Letter of Intent Site Development Plan

Hammers Construction, Inc.
1411 Woolsey Heights
Colorado Springs, CO 80915
Project Name: CBP 2-1, Lot 5

Letter of Intent_V2_Redlines.pdf Markup Summary

LANDSCAPE PLAN

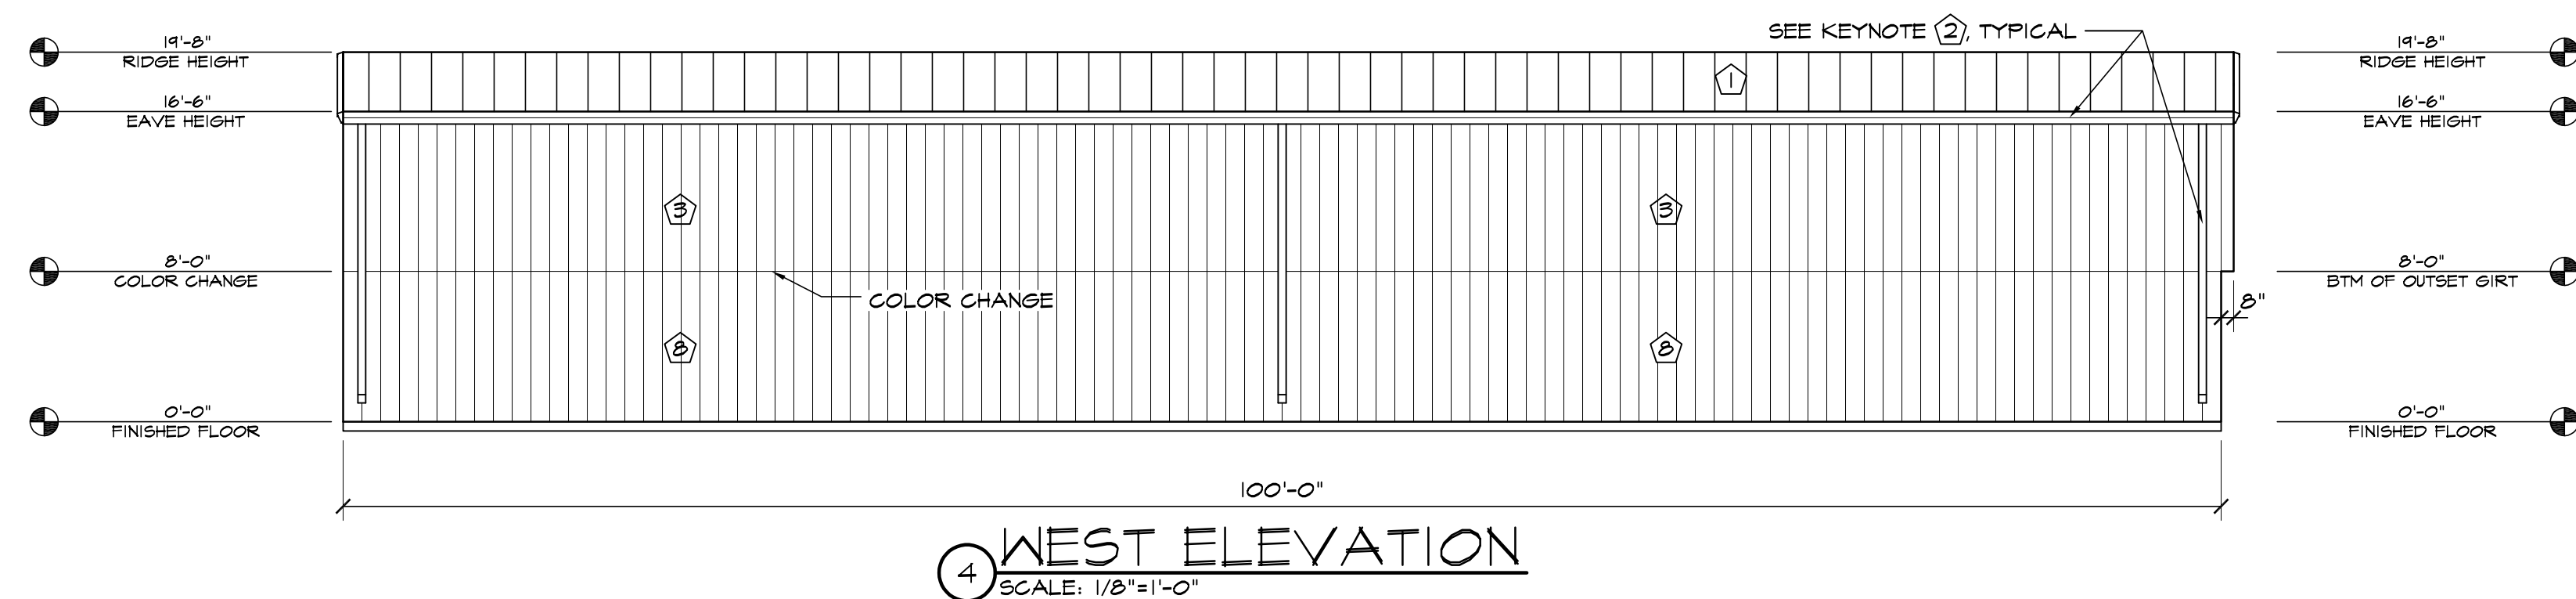
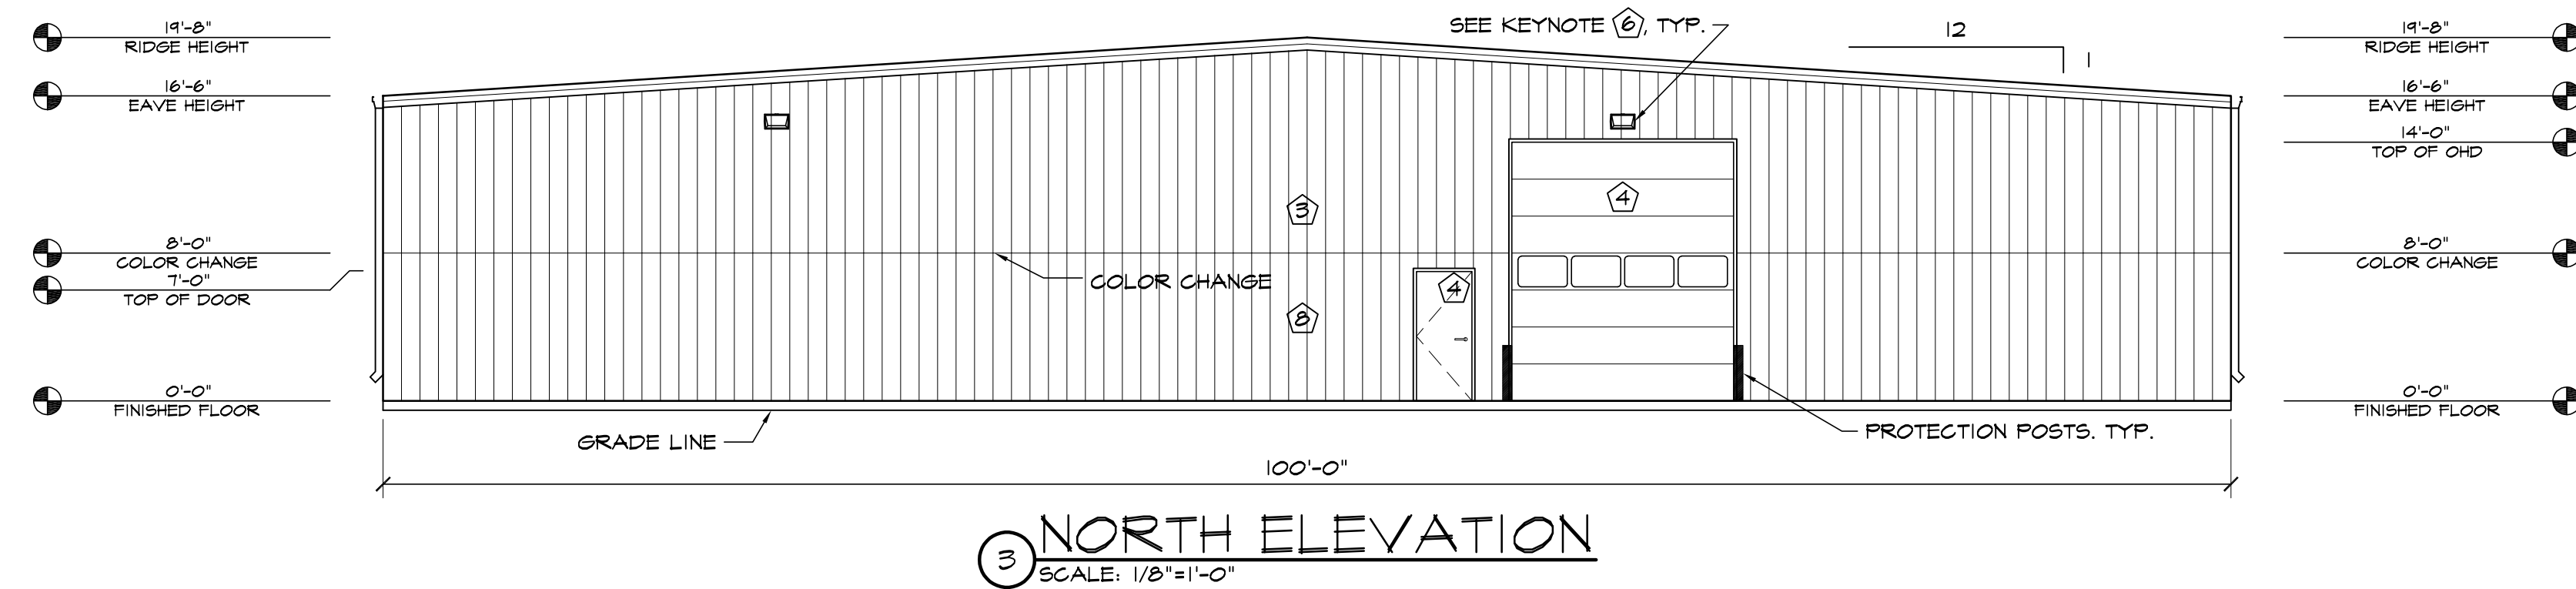
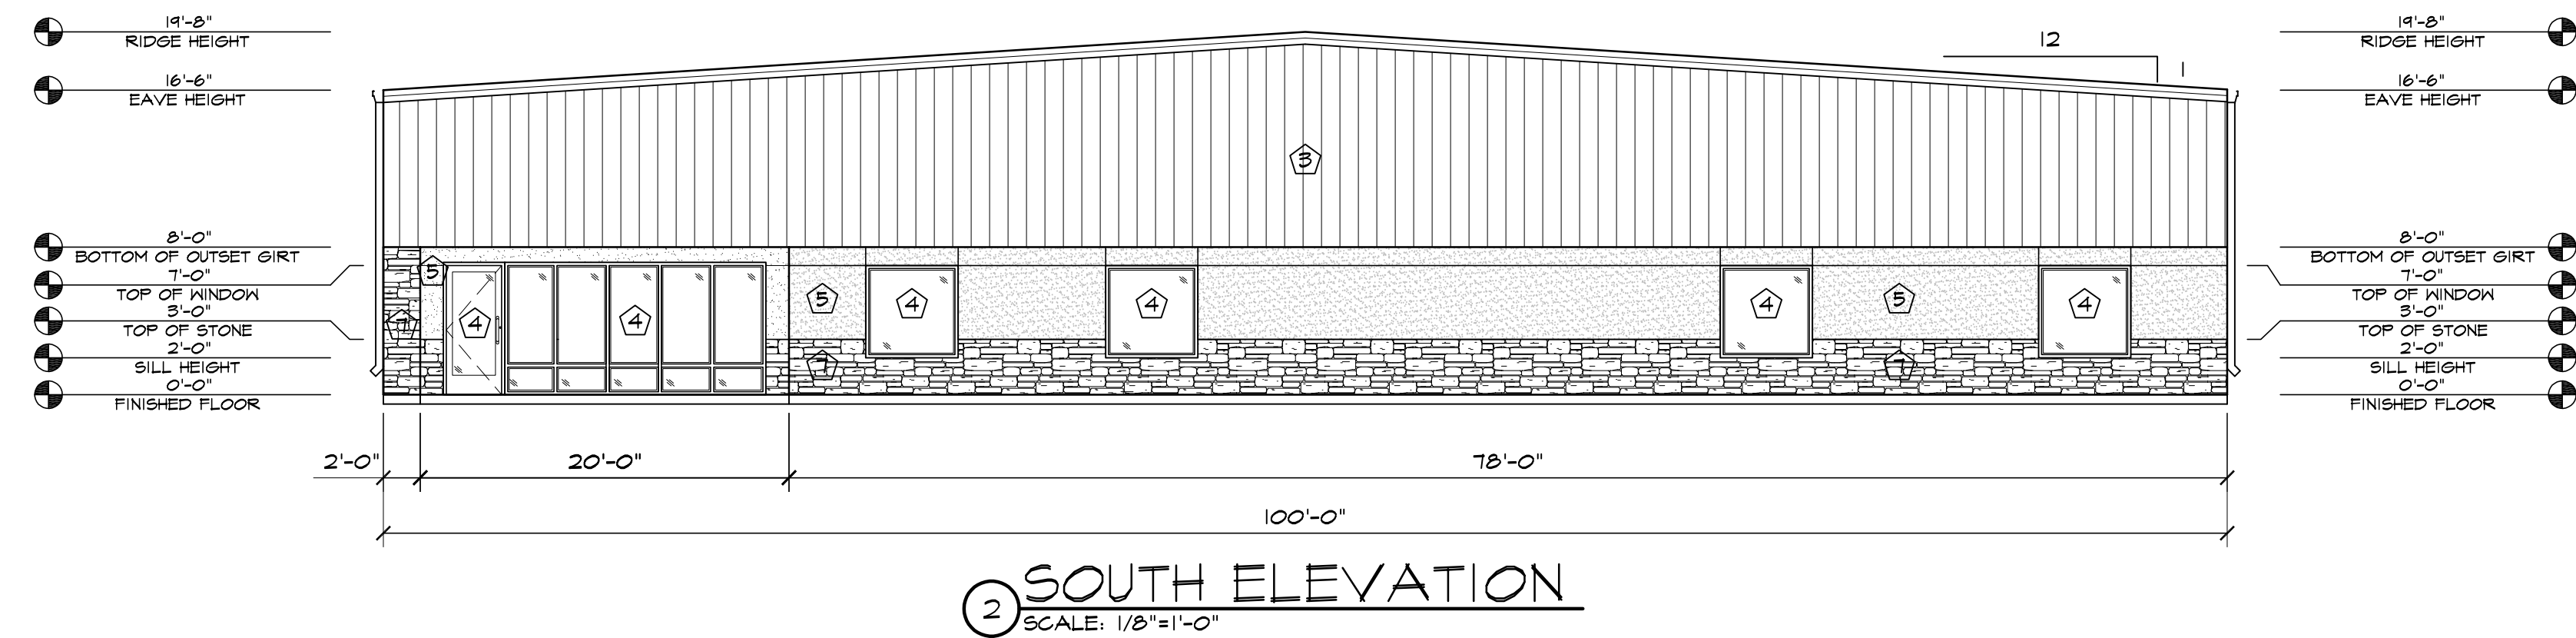
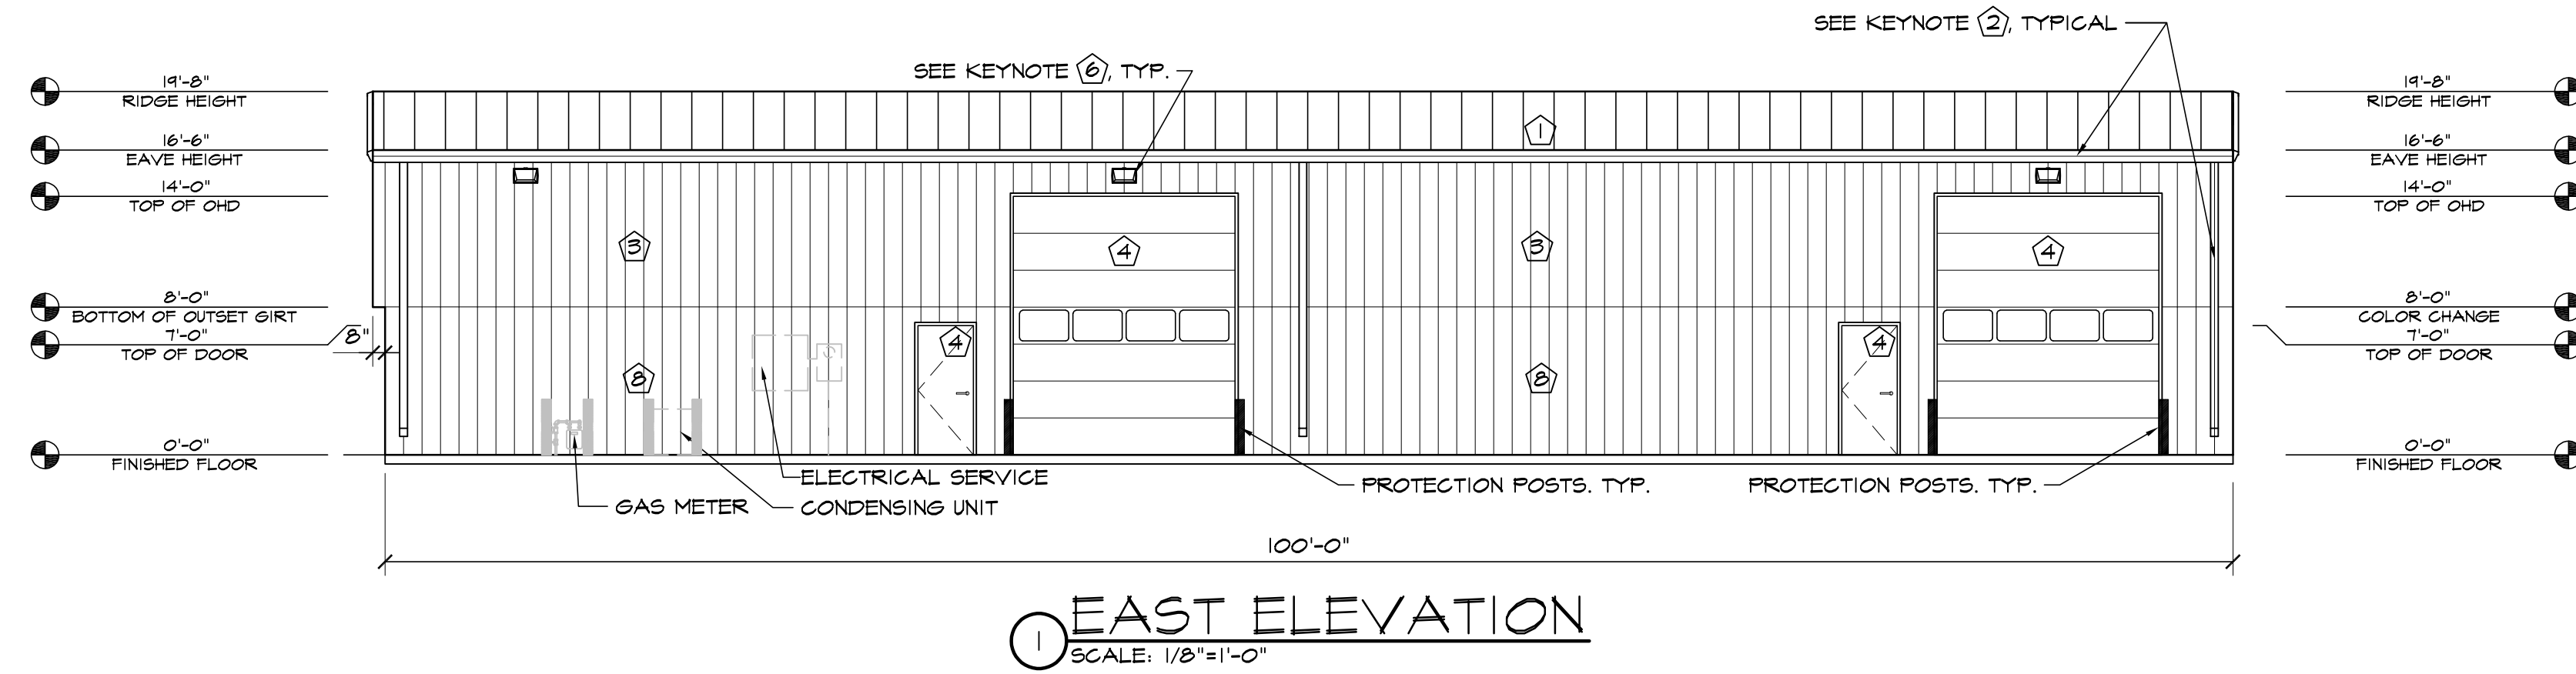
Internal Landscaping requirements are also being waived; Please revise statement and include adequate justification explaining the reason that an alternative to the internal landscaping requirements are being sought, as well as mitigation/how the alternative plan meets the intent of the Code.

*Please note that the authority of the Director to approve alternative landscape designs does not allow the Director to eliminate the requirements or to diminish the total landscape area required by Chapter 6 of the Code.

Please also revise/reorganize justification points to separately list and justify the various requirements that you're seeking alternative design for / relief from.

On behalf of Hammers Construction, we are requesting approval for alternate landscape plan for Lot 5 based on the following points.

- Waive landscape setback tree requirement along Marksheffel Road frontage. 314 LF, 16 trees required.
- Fiber optic, drainage, and electrical easements hinder buffer tree placement options.
- Landscape plan, dated 10-29-20 (revised), complies with all other landscape policies required by El Paso County.
- The steep slope between Marksheffel Road and the existing retaining wall makes it difficult for safe access to plant required trees, maintain the trees, and get irrigation to the trees. It is difficult for trees to survive on steep slopes.
- Marksheffel Road roadway surface sits above the property, therefore a landscape buffer would not be visually effective.
